From: Stephanie Evans [REDACTED]
Sent: 19 February 2021 16:16
To: Planning.Responses <Planning.Responses@arun.gov.uk>
Subject: RE: Planning Consultation on: AL/20/21/PL

Application No: AL/20/21/PL
Registered: 18th February 2021
Site Address: Land At Wings Nursery Lidsey Road Woodgate PO20 3SU
Grid Reference: 493715 104134
Description of Works: Demolition of Wings House & erection of 71 No. replacement dwellings (70 net new dwellings), access arrangements, sustainable drainage measures, public open space, landscaping & all other associated works (resubmission following AL/46/20/PL). This application is a Departure from the Development Plan.

T7, a large mature oak tree with multiple suitable features for roosting bats. View looking east.

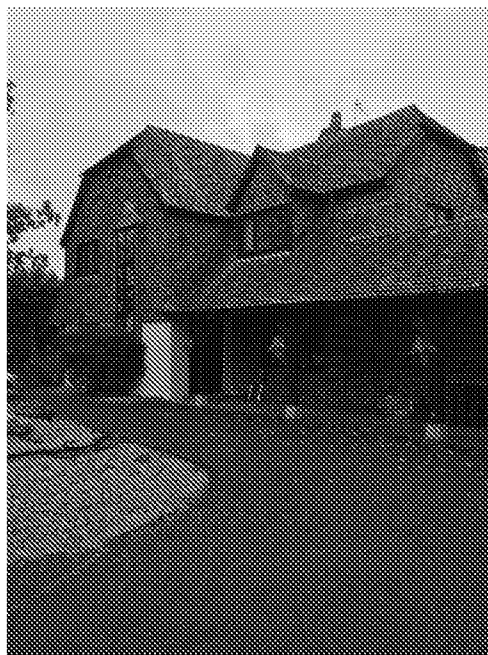
The demolition of all the buildings on site and the felling of T7 should be carried out between September and January inclusive to avoid impacting on breeding birds. If demolition during the breeding season is unavoidable, then potential nesting habitat must be inspected shortly before work commences by a suitably qualified ecologist to identify active birds' nests. Should they be present, the nest and a suitable buffer around it, must be retained until it has been confirmed by an ecologist that the young last left the nest or that it is no longer active.

Photograph 2
Eastern and northern elevations
of Building 1

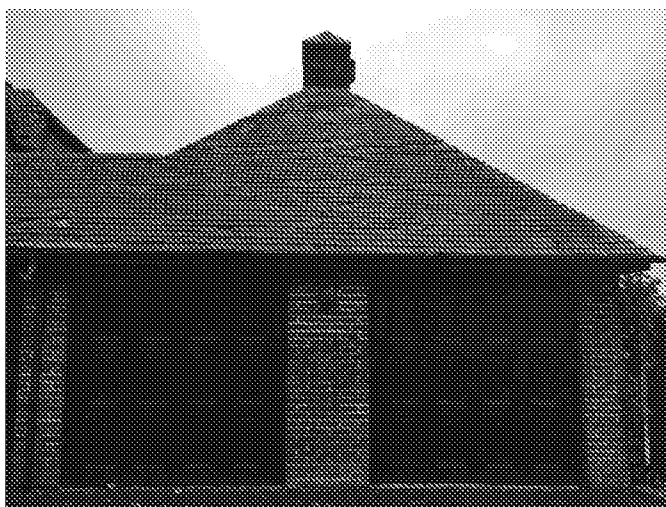
A preliminary bat roost assessment was undertaken at the site and then subsequent emergence surveys. This concluded that buildings 1 and 2 provided an occasional roost for a small number of pipistrelle bats. Therefore the proposals represent a loss of these roosts and so a Natural England Bat Licence will be required. In the event that planning permission is secured, **the mitigation detailed within sections 5.3 to 5.7 of the report and as detailed within the Natural England Bat Licence method statement should be followed in its entirety.**
